## Meeting note

<b>File reference</b>	TR050005 West Midlands Interchange (WMI)
<b>Status</b>	<b>Final</b>
<b>Author</b>	Louise Evans
<b>Date</b>	7 September 2017
<b>Meeting with</b>	Four Ashes Limited (FAL)
<b>Venue</b>	Temple Quay House
<b>Attendees</b>	The Applicant  Peter Frost (Kilbride) Laura-Beth Hutton (Eversheds Sutherland) Matt Royall (Environ) Morag Thomson (Eversheds Sutherland) Sue Willcox (Quod)  The Planning Inspectorate (the Inspectorate)  Emre Williams – Case Manager Robert Ranger – Case Manager Richard Hunt - EIA and Land Rights Advisor Emma Cottam - EIA and Land Rights Advisor Dave Anthony - Legal Advisor Louise Evans – Case Officer
<b>Meeting objectives</b>	Review of the Inspectorate’s comments on the draft application documents
<b>Circulation</b>	All

## West Midlands Rail Freight Interchange: Comments on draft documents, August 2017

Drawing No: Sheet 4 of 12 Revision: v0

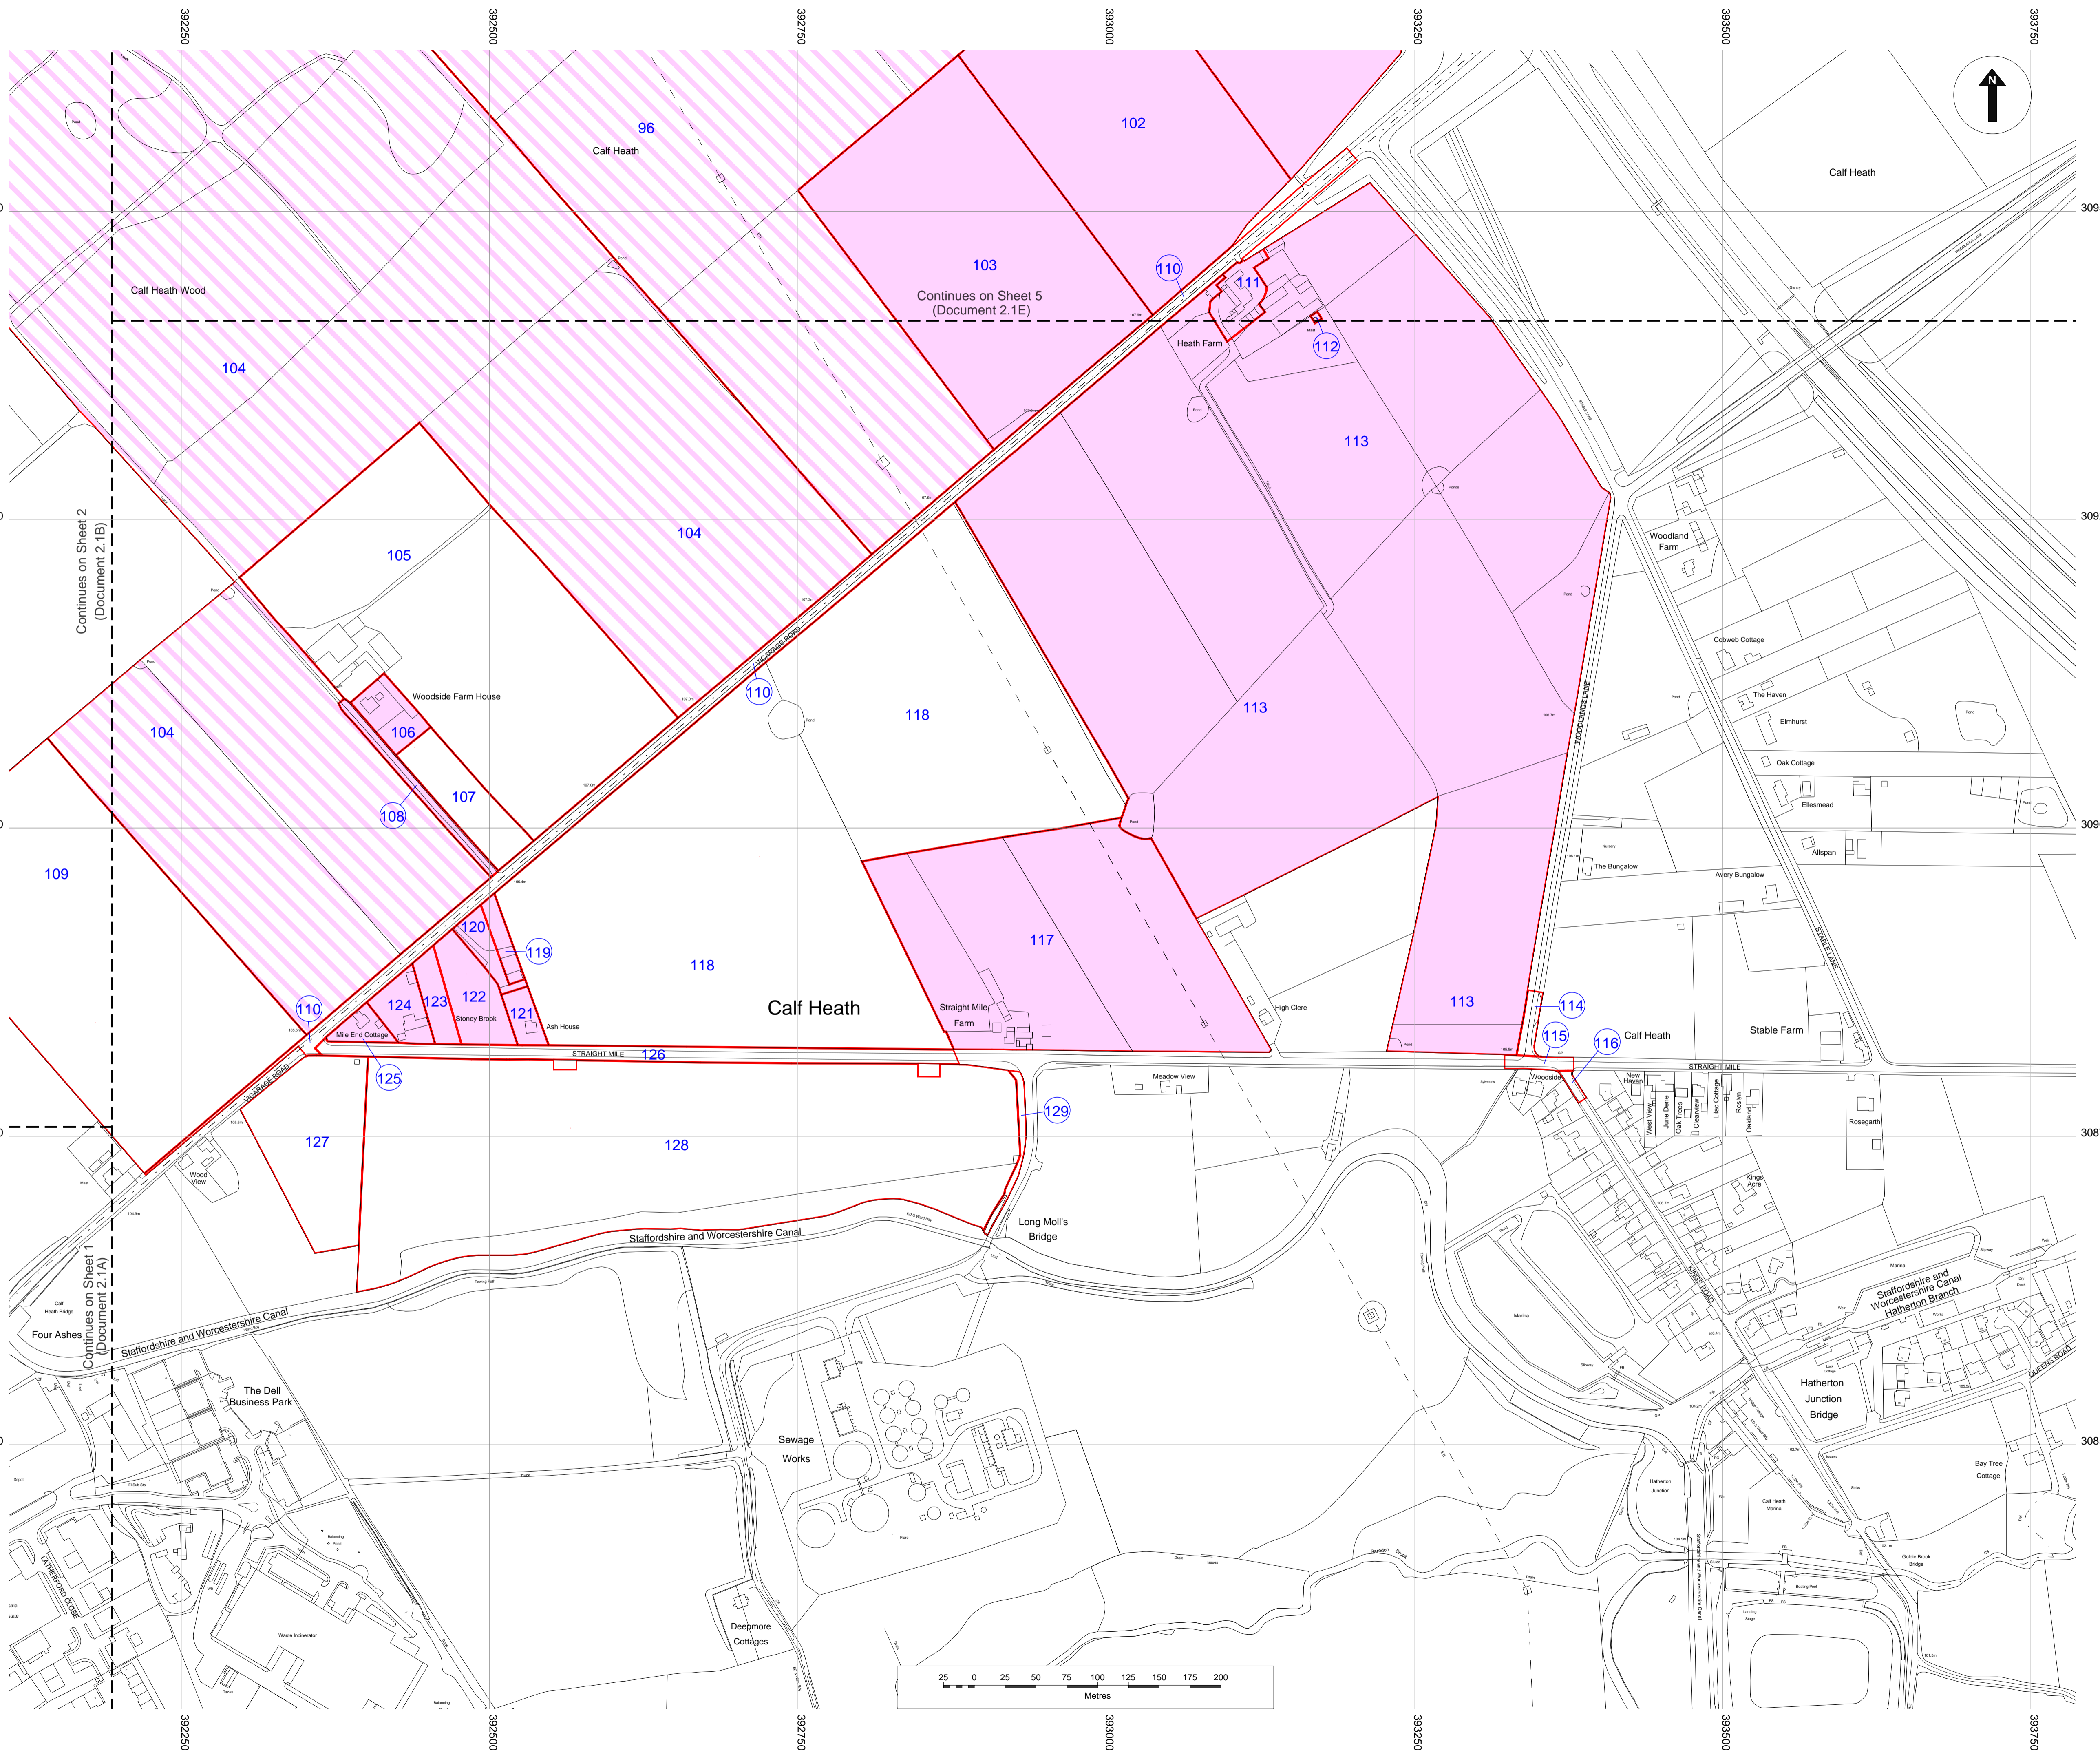
<b>Q No.</b>	<b>location</b>	<b>Description of issue</b>	<b>Question/Comment</b>
<b>1</b>	General	Key	The categories of land shown are broader than is suggested by Annex C of the 2013 guidance.
<b>2</b>	General	Numbering of plots	The size of the text used to label the plots and the choice of colour (blue on blue or purple) makes reading the plans difficult on a computer screen. Since documents are distributed electronically, this could make the plans less useful to interested parties.
<b>3</b>	General	Plots 71 to 74	These plots can be distinguished but with difficulty. The insets differ between the works and land plans.
<b>4</b>	Sheets 1 and 2	Scale	The scale of these plans is as small as could be appropriate; the use of insets for areas where plots are denser is helpful.
<b>5</b>	General	Plot lines	On a computer screen, the plot lines are not easily distinguished from the field boundaries. The weight of the line could helpfully be increased.
